Responses to matters raised in Rule 17 Letter

The Yorkshire and Humber (CCS Cross Country Pipeline) Development Consent Order

The following table sets out the Examining Authority’s requests for further information in relation to the draft Order granting development consent for the proposed Yorkshire and Humber CCS Cross Country Pipeline as set out in its letter dated 18 March 2015 (the “Rule 17 Letter”). Responses are required by **26 March 2015**.

**DRAX PIG TRAP  
PLANNING ARRANGEMENT**

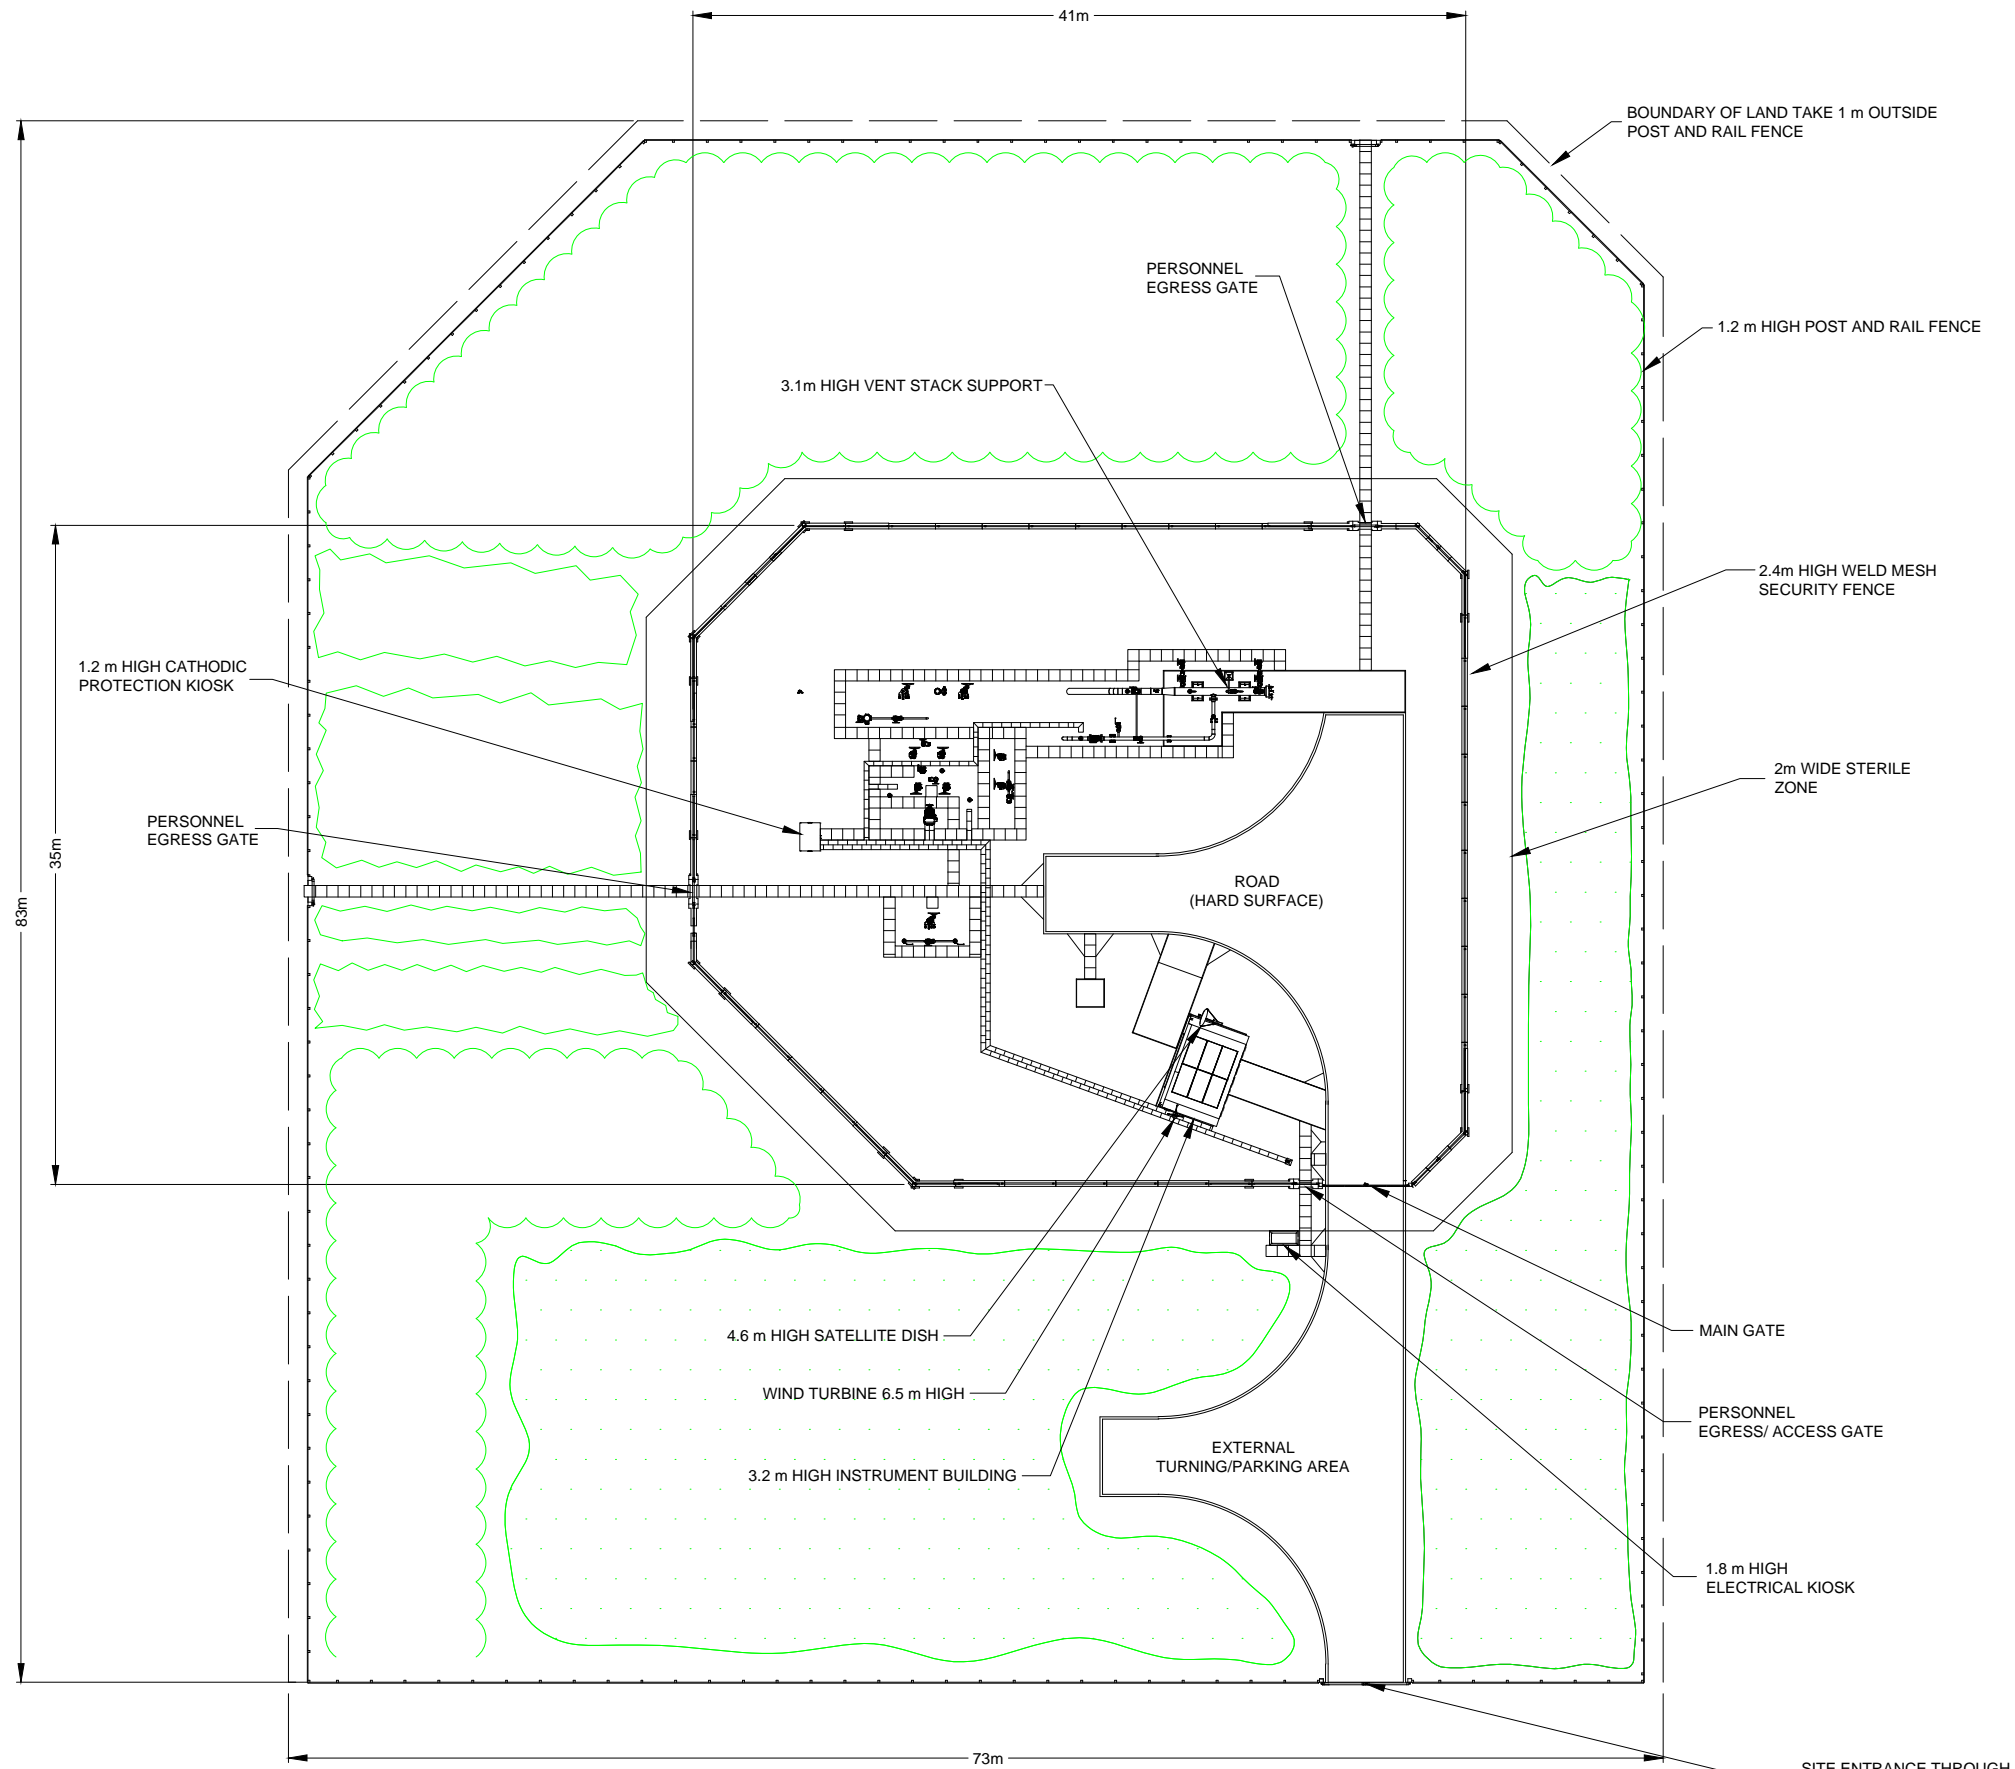
REF NO.	RESPONDENT	QUESTION	RESPONSE
		required in accordance with section 135(1)?	National Grid considers that negotiations with TCE in relation to the voluntary grant of rights for those elements of the Onshore Scheme that relate to Crown interests are progressing well and that TCE confirmation for the purposes of section 135(2) would form part of agreement reached. National Grid notes that there is already an agreement for lease in place for the storage site required for the Offshore Scheme.
5	National Grid	Please would the applicant indicate the latest position in the negotiations with regard to the respective protective provisions for statutory undertakers and others as listed in Document 13.4 received at deadline 4.	Please refer to the document entitled "Position in respect of statutory undertakers and others" submitted at Deadline 5 (document reference 14.4)
6	National Grid / Selby District Council	<p>Schedule 2 Plans: Part 6 Requirement 3 of Schedule 3</p> <p>Parameters</p> <p>Table 1</p> <p>Drax Pig Trap</p> <p>With regard to the Drax Pig Trap, the revised draft DCO received at deadline 4 and revised plans 2.18, 2.19, 2.20 and 2.22 also received at deadline 4 show an increase in the height of the security fence from 2.4m to 2.88m. This height appears to have been gained by the addition of three strands of barbed wire above the weld mesh security fence. These revised plans now reflect the fencing arrangements at other above ground installations (AGIs).</p> <p>Please can the applicant confirm how this increase in height will impact upon the assessment of visual impact made in the Environmental Statement?</p> <p>Please could Selby District Council comment on whether the additional 0.48m height of the security fence affects their assessment of the visual impact of the Drax Pig Trap?</p>	<p>National Grid can confirm that the submission of plans showing a security fence of 2.88m was made in error at Deadline 4. The security arrangements at Drax PIG Trap are different to those at other above ground installations because the site will fall within the curtilage of the White Rose CCS Project and therefore will be subject to additional security; accordingly it is not considered necessary to include the additional three strands of barbed wire at this site. A further revision to the plan, only to reinstate the fence height of 2.4m, will be provided at Deadline 6.</p>
